Our Case Number: ABP-310286-21

Re: Railway works and all works necessary to eliminate and, where necessary, upgrade seven numbered level crossings and carry out all associated and ancillary works along a 24-kilometre section of the Dublin to Cork Railway Line.
Fantstown, Thomastown, Ballyhay, Newtown, Ballycoskery (Ballyhea Village), Shinanagh and Buttevant, Co. Cork and Co. Limerick.

RE: An Bord Pleanála Case reference: NA04.310286

4.0 NEW DEVELOPMENT - GROUNDS OF APPEAL AND THE REASONS, CONSIDERATIONS AND ARGUMENTS ON WHICH THEY ARE BASED:

Figure 2.15: XC219 Buttevant Proposed Realignment

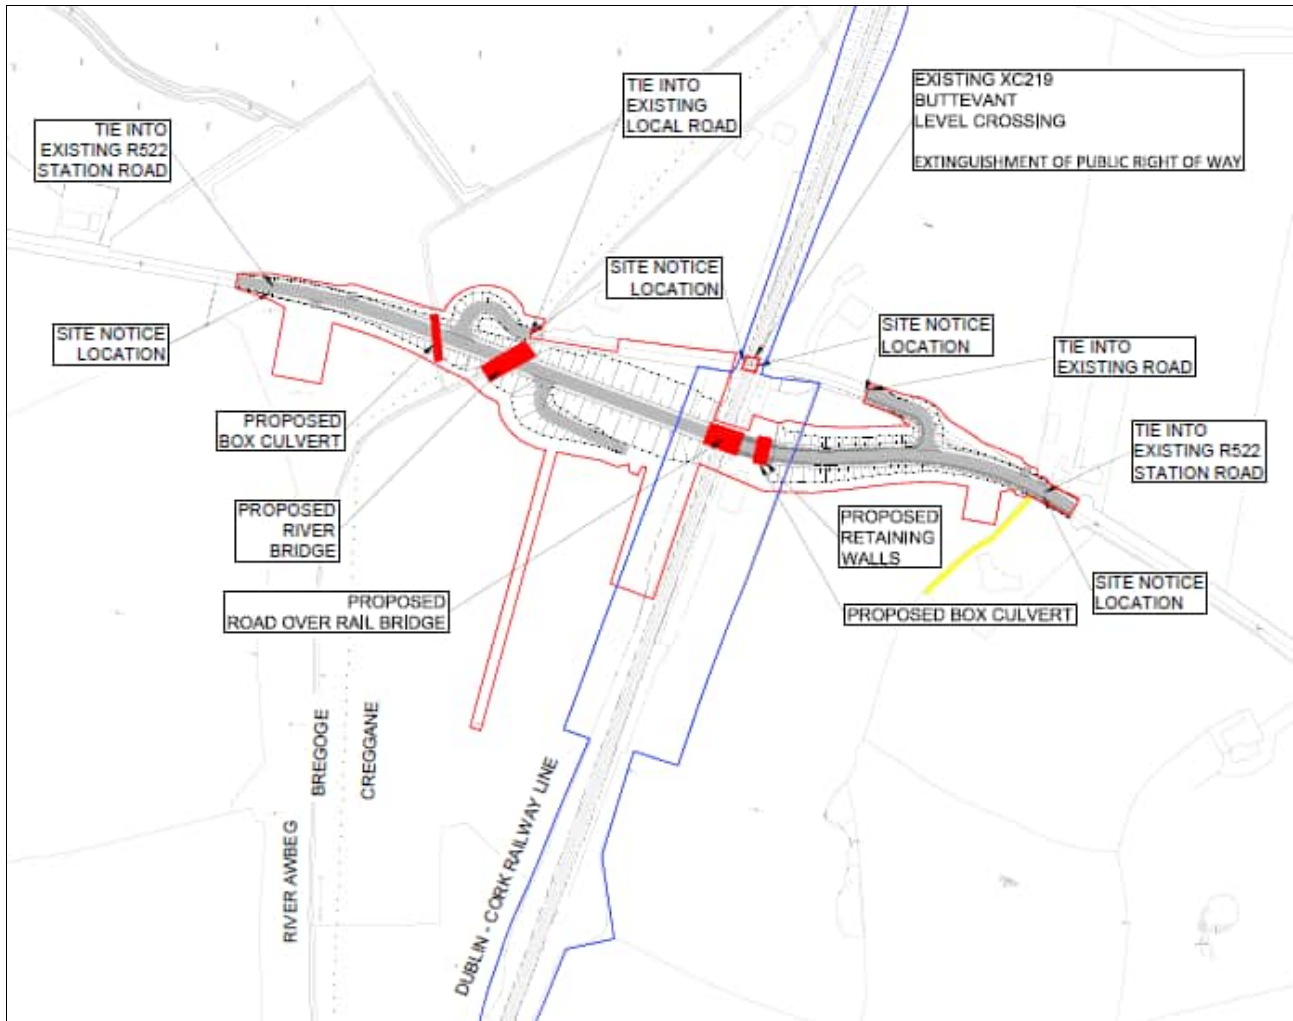
1. *"Existing access on the north east corner of the field Folio CK26597F (owned by Daniel Lucey) is not catered for in relation to reduction of sight lines and road safety."*

If this application is granted at its present format without a link to the existing road to the north, future development options for the Appellant's lands will be eliminated, unless adequate space is provided for the entrance with adequate sight lines in accordance latest roads guidelines. The entrance width should be min. 10.5m to accommodate a 6.5m wide road with 2m wide footpath at either side with junction radii not less than 10m. Surely, this entrance will be required at construction stage to cater for temporary land acquisition as shown on Plan 3A XC219 – Buttevant and left in situ for any future development for the Appellant's lands.

2. *"Access on the northwest corner of the field Folio CK26597F (owned by Daniel Lucey) is not provided."*

The access is still not provided by way of underpass to the existing road.

3. *"Folio CK26597F (owned by Daniel Lucey) is divided with no link access under proposed road".*

You might note that CIE has catered for an access for themselves, but there is no access still provided for the Appellant in the latest drawings. It is a safer option to provide access onto the existing road.

4. *"The short spur road also divides Folio CK26597F (owned by Daniel Lucey)."*

5. *"The proposed new road as designed would landlock these lands from further development and will greatly reduce capacity for future developments of the lands Folio CK26597F (owned by Daniel Lucey)"*

The new road design in its present format without a link denies access to the majority of the holding owned by the Appellant in relation to the future development.

7. *"Compromise will be required prior to formalising the design."*
No proper compromises were made in relation to the link and access to the existing road from the southern portion of the holding owned by the Appellant prior to formalising the design.

8. *"Has RSA approved speed limit change from 80kph to 50kph?"*
Still applicable to this submission.
9. *"To satisfy the needs of the holding, the design would need an access to the north-west part of the lands by providing an underpass under the proposed road next to the western boundary where adequate headroom can be achieved. It would also need a new access onto the old road with adequate sight lines and safe stopping distances"*
Still applicable to this submission.
